KIRKLEES METROPOLITAN COUNCIL INVESTMENT & REGENERATION SERVICE

DELEGATED DECISION TO DETERMINE PLANNING APPLICATIONS

Reference No:	2024/62/91268/E
Site Address:	3, Low Common, Farnley Tyas, Huddersfield, HD4 6ST
Description:	Reinstallation and addition of windows, internal alterations and rooflights
Recommending Officer:	Molly Storer

Officer Report

North West Elevation - 1:50

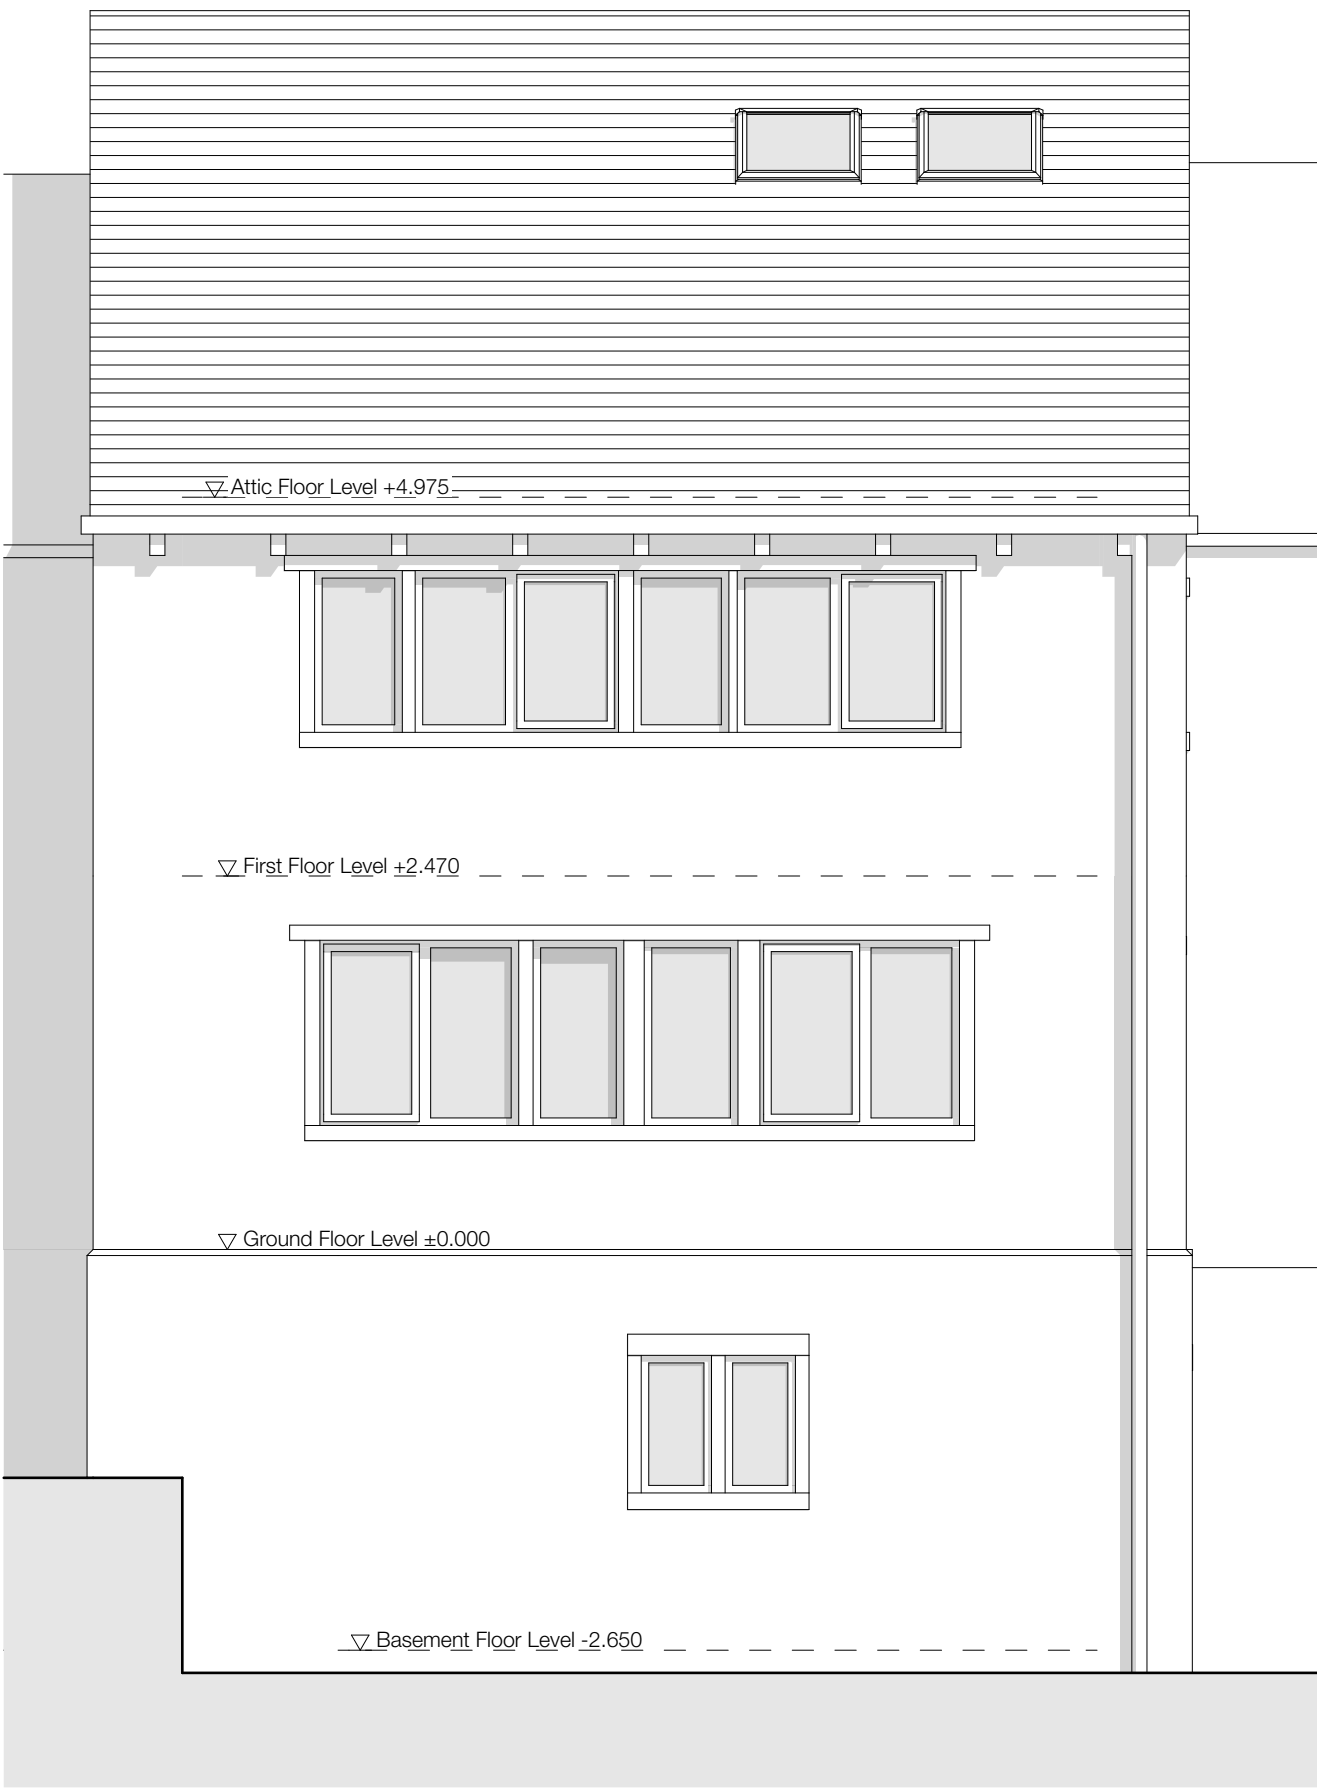
The proposed additional window on the first floor of the southwest elevation would match the design of the existing windows on the same elevation on the attic floor. The re-installed windows on the northwest elevation would be ashlar windows to match that of the other windows on the ground and first floor on this elevation. The roof lights on the northwest elevation would be

minimal in scale and subservient to the roof plane. The design, materials, and detailing of the alterations are acceptably in keeping with the host dwelling and the local character and are therefore considered acceptable from a visual amenity perspective.

South West Elevation - 1:50

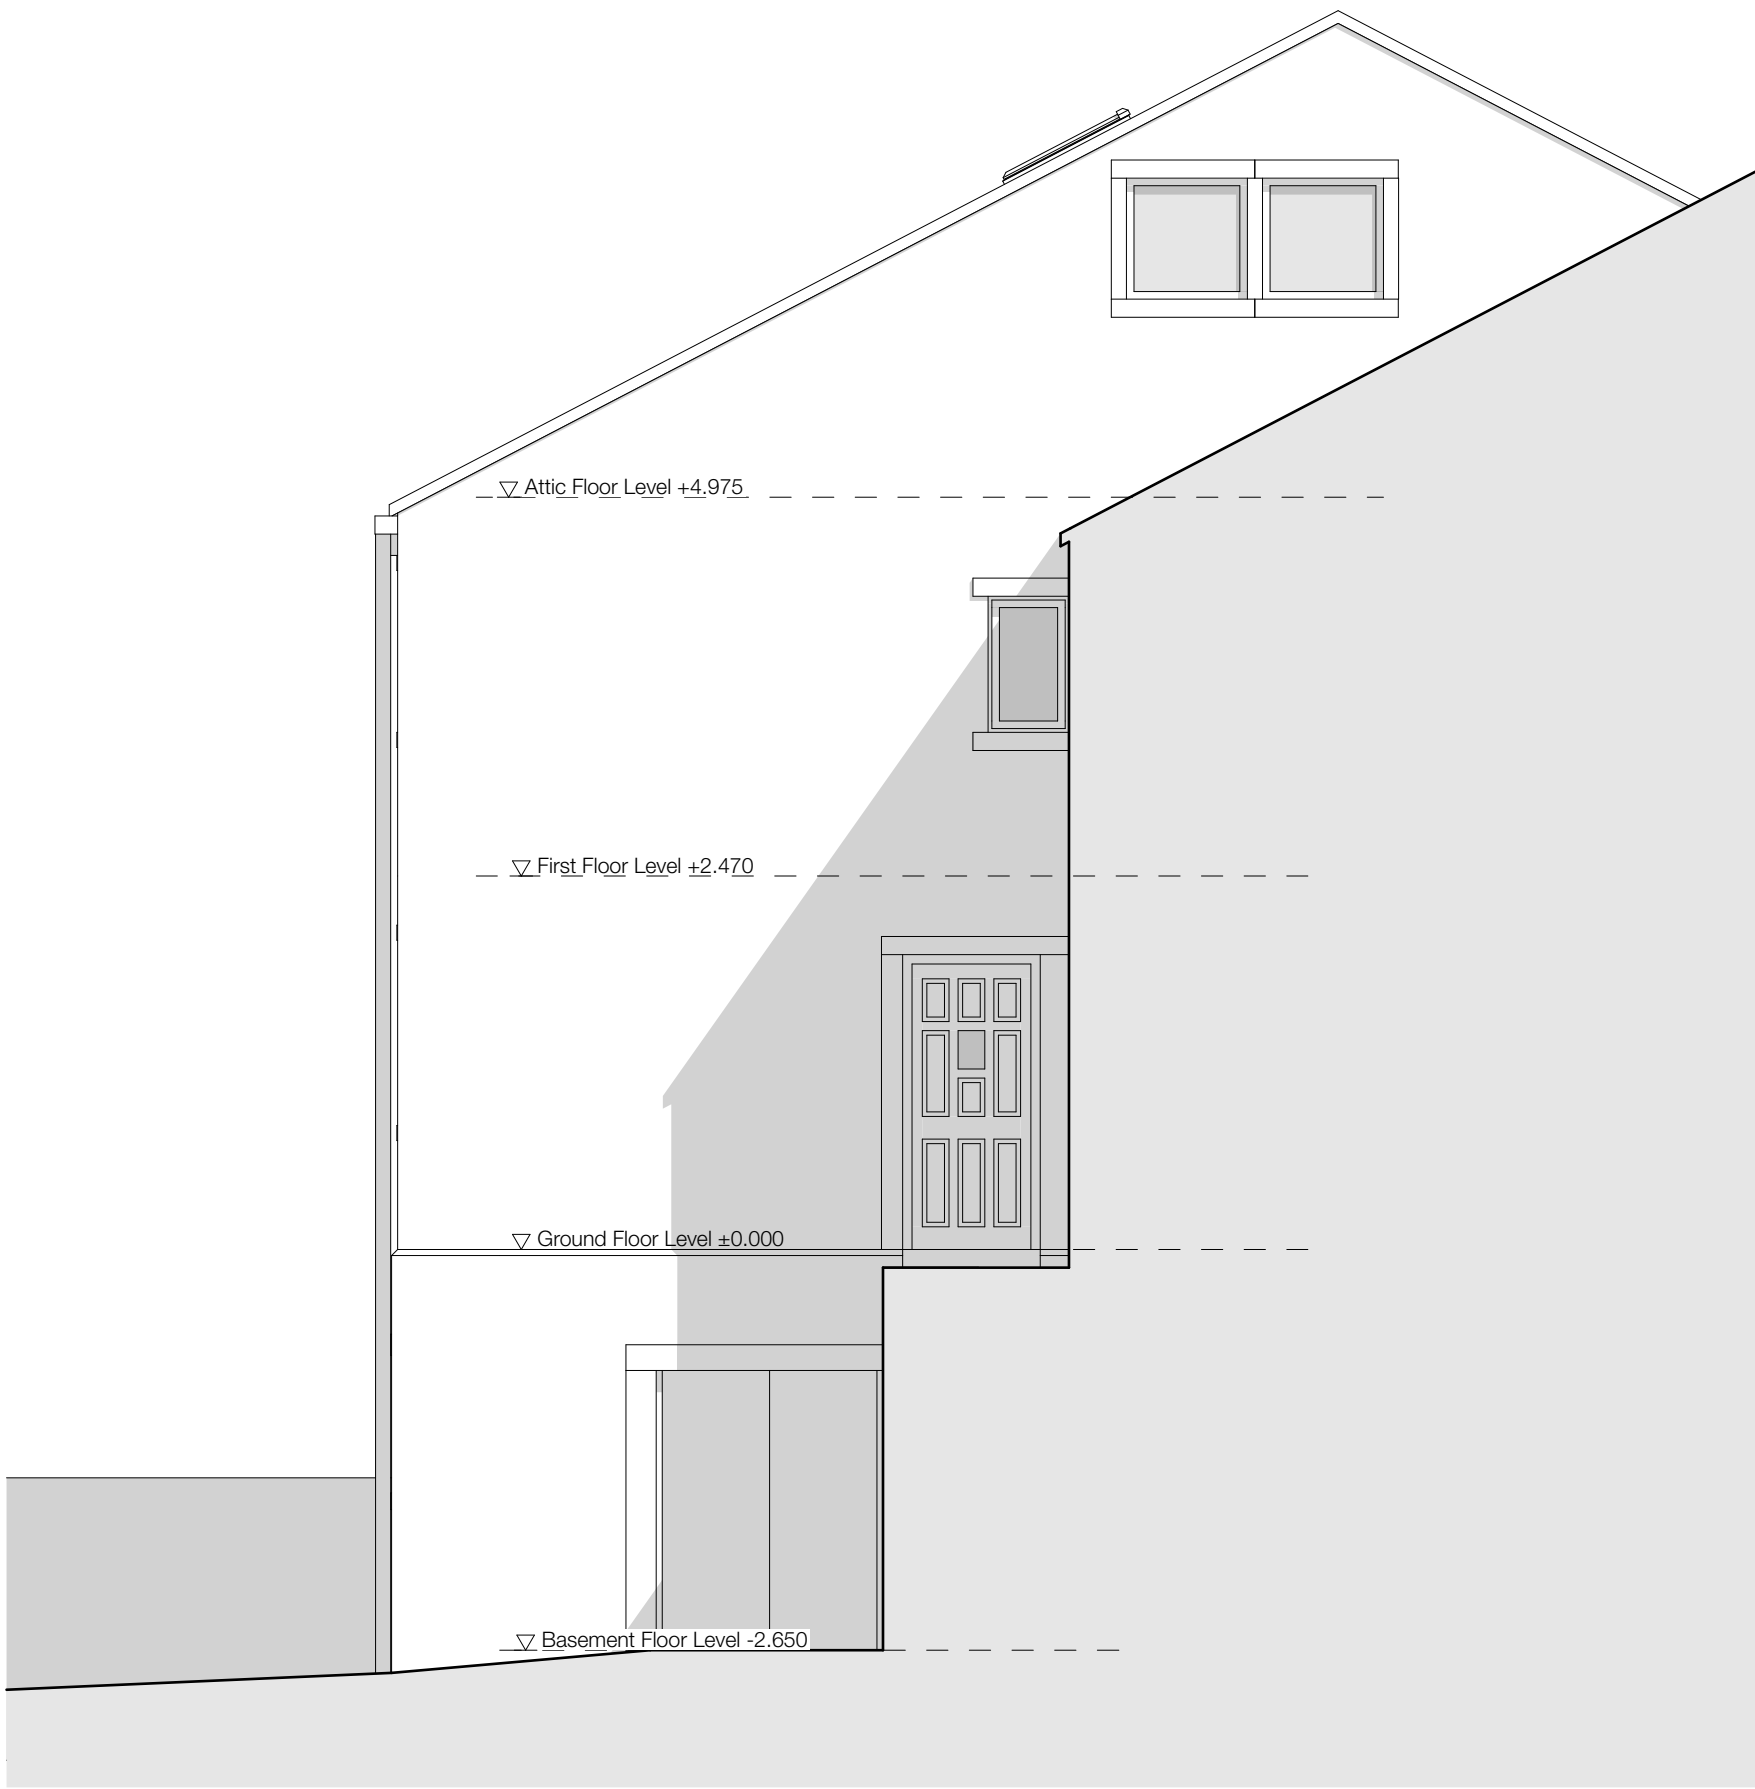
The proposed first floor window in the southwest elevation would be in close proximity to the first-floor windows at No.2, however plans show that this window will serve a shower room. In the event that planning permission is approved, a condition is recommended to ensure that this window is obscurely glazed. Due to the windows in the basement floor being a reinstalment of existing windows, these are not considered to have any added adverse impact. In addition, the roof lights are also considered to have limited impact as they will not be easily visible from No.2. Given the limited scale of the proposal, it is considered to have no significant impact on the residential amenity of this neighbour.

3. The window to the shower room on the southwest elevation as shown on drawing number 3574 (0-) 02 shall be obscurely glazed and be non-opening.
Reason: In the interests of residential amenity and in accordance with Policies LP2 and of the Kirklees Local Plan and policies within Chapter 12 of the National Planning Policy Framework.
